V2_Drainage Report - Final.pdf Markup Summary 12-19-2023

Sheet: 1 of 2

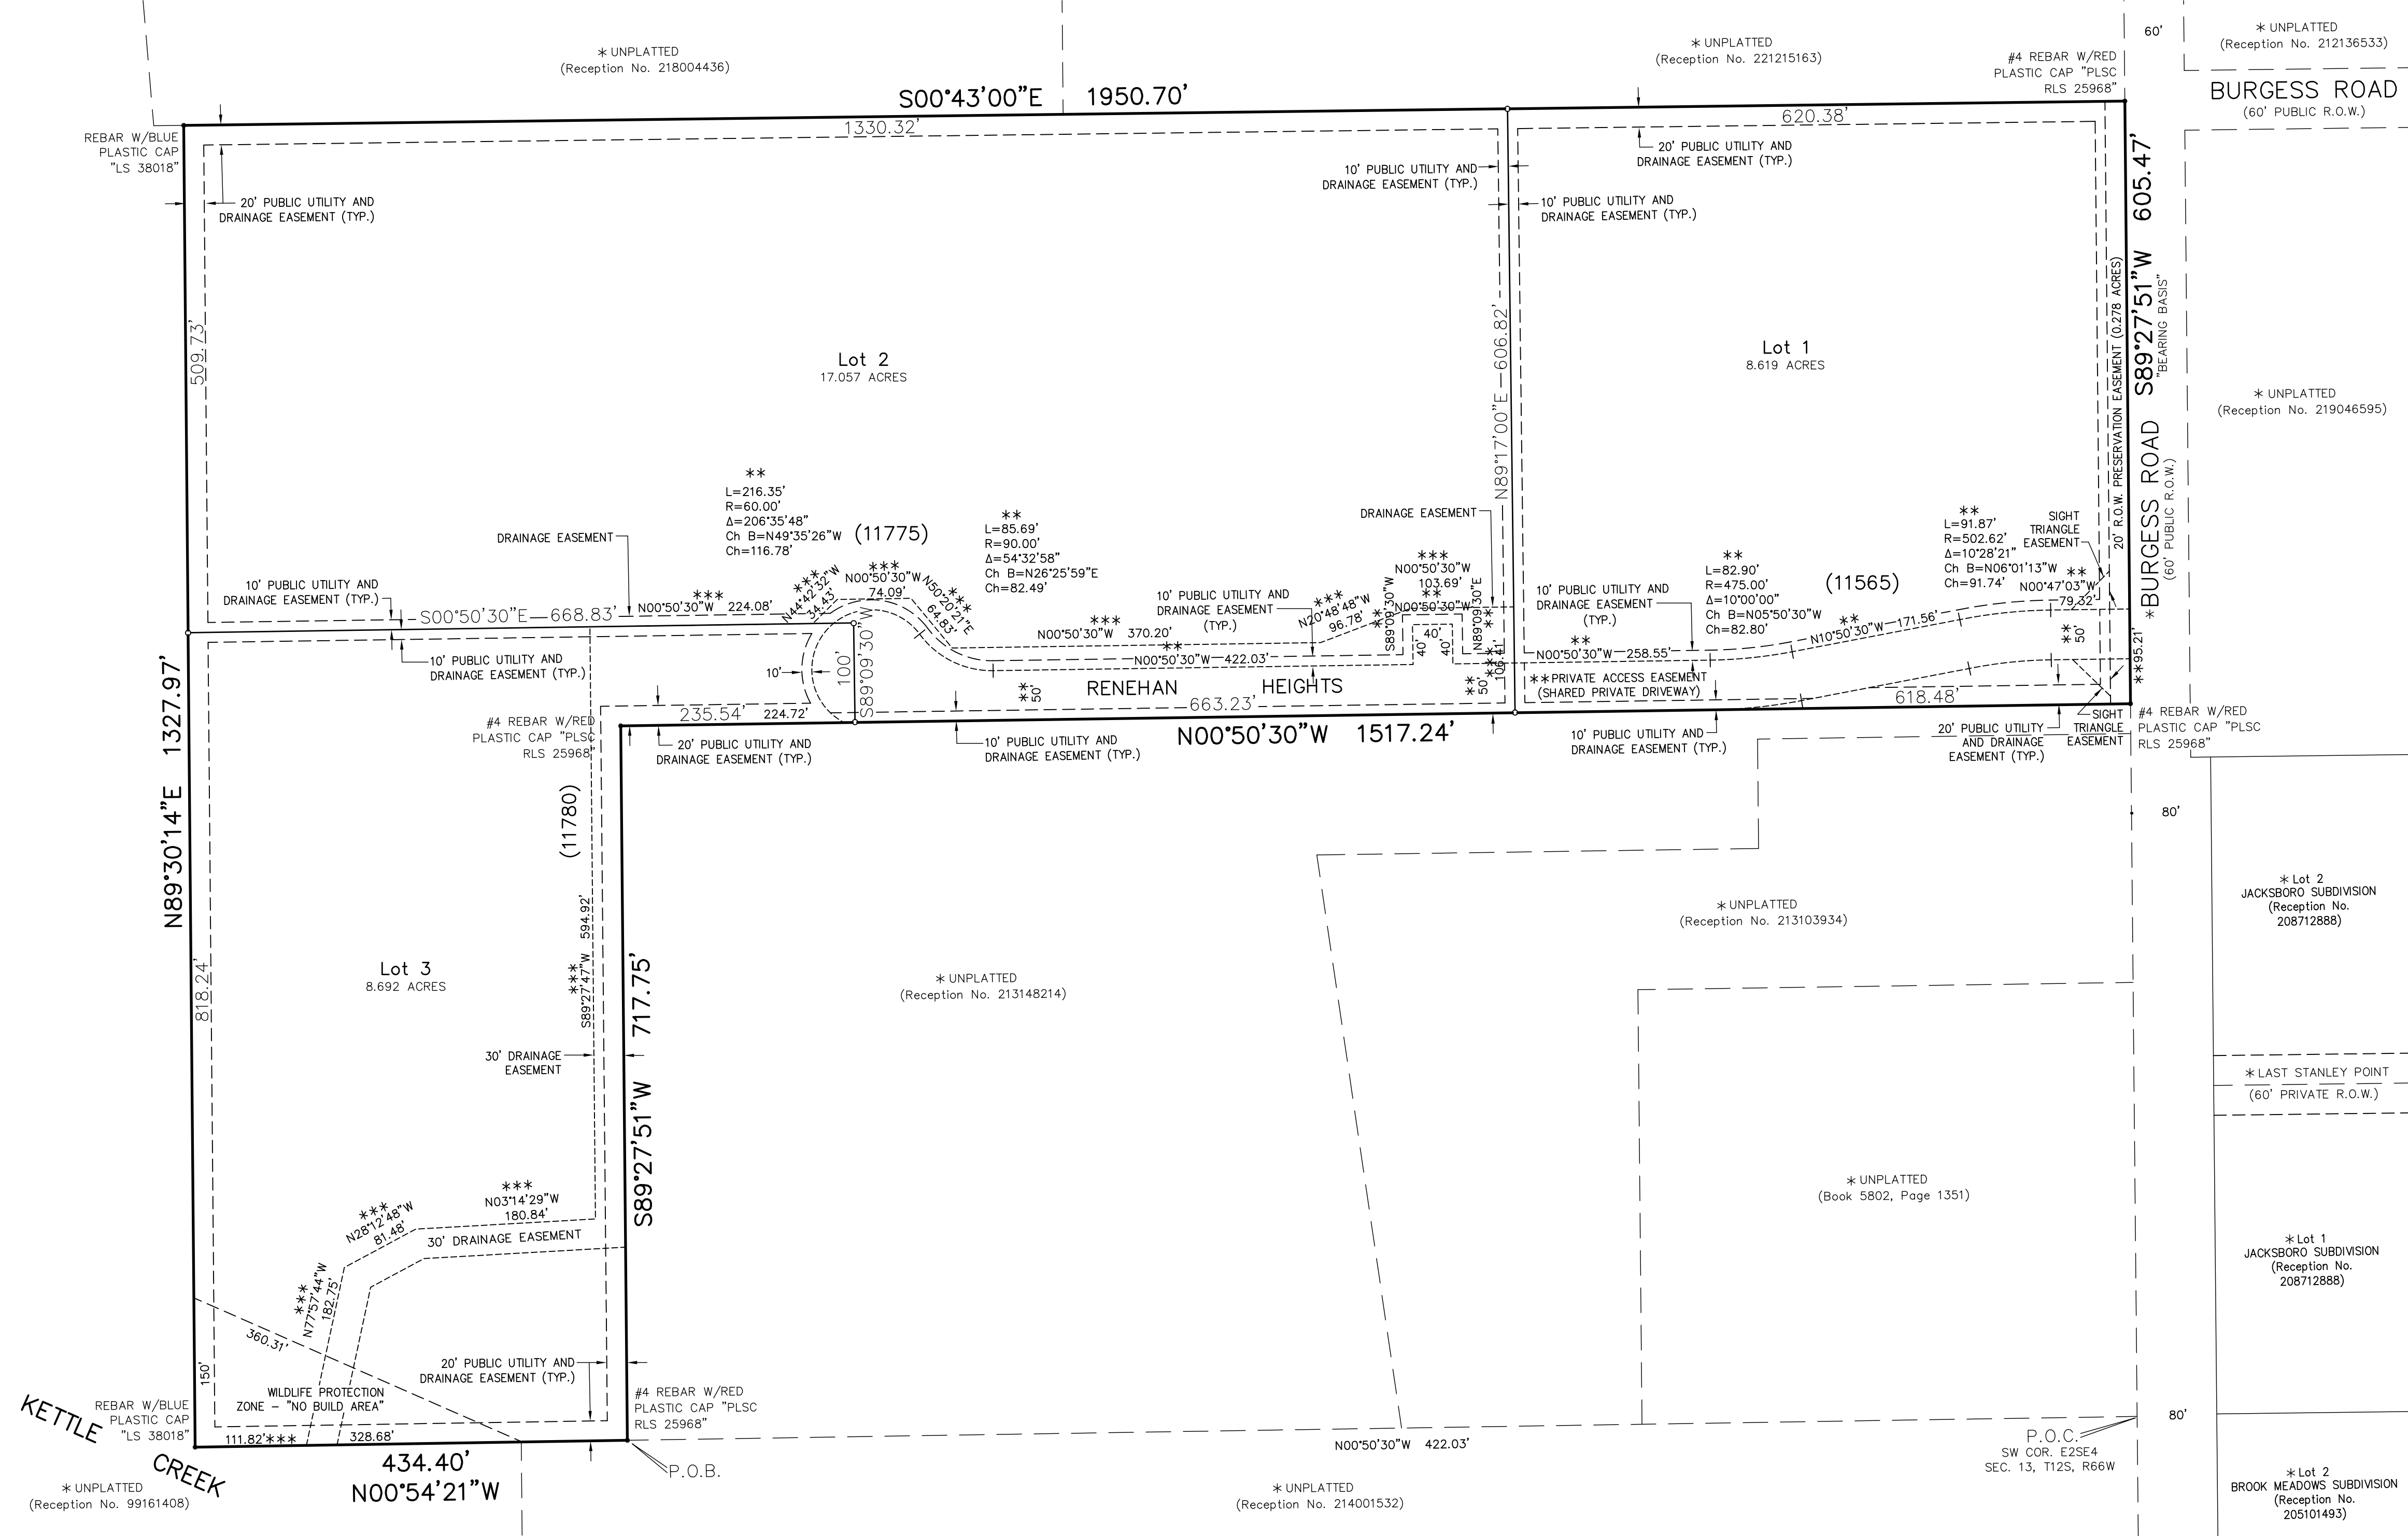
that conveys existing flows in existing channels. A 15-foot drainage easement is proposed to convey these flows to a heavily vegetated area. Iteration to the topography would be required.

Revise to 30' per drainage map.
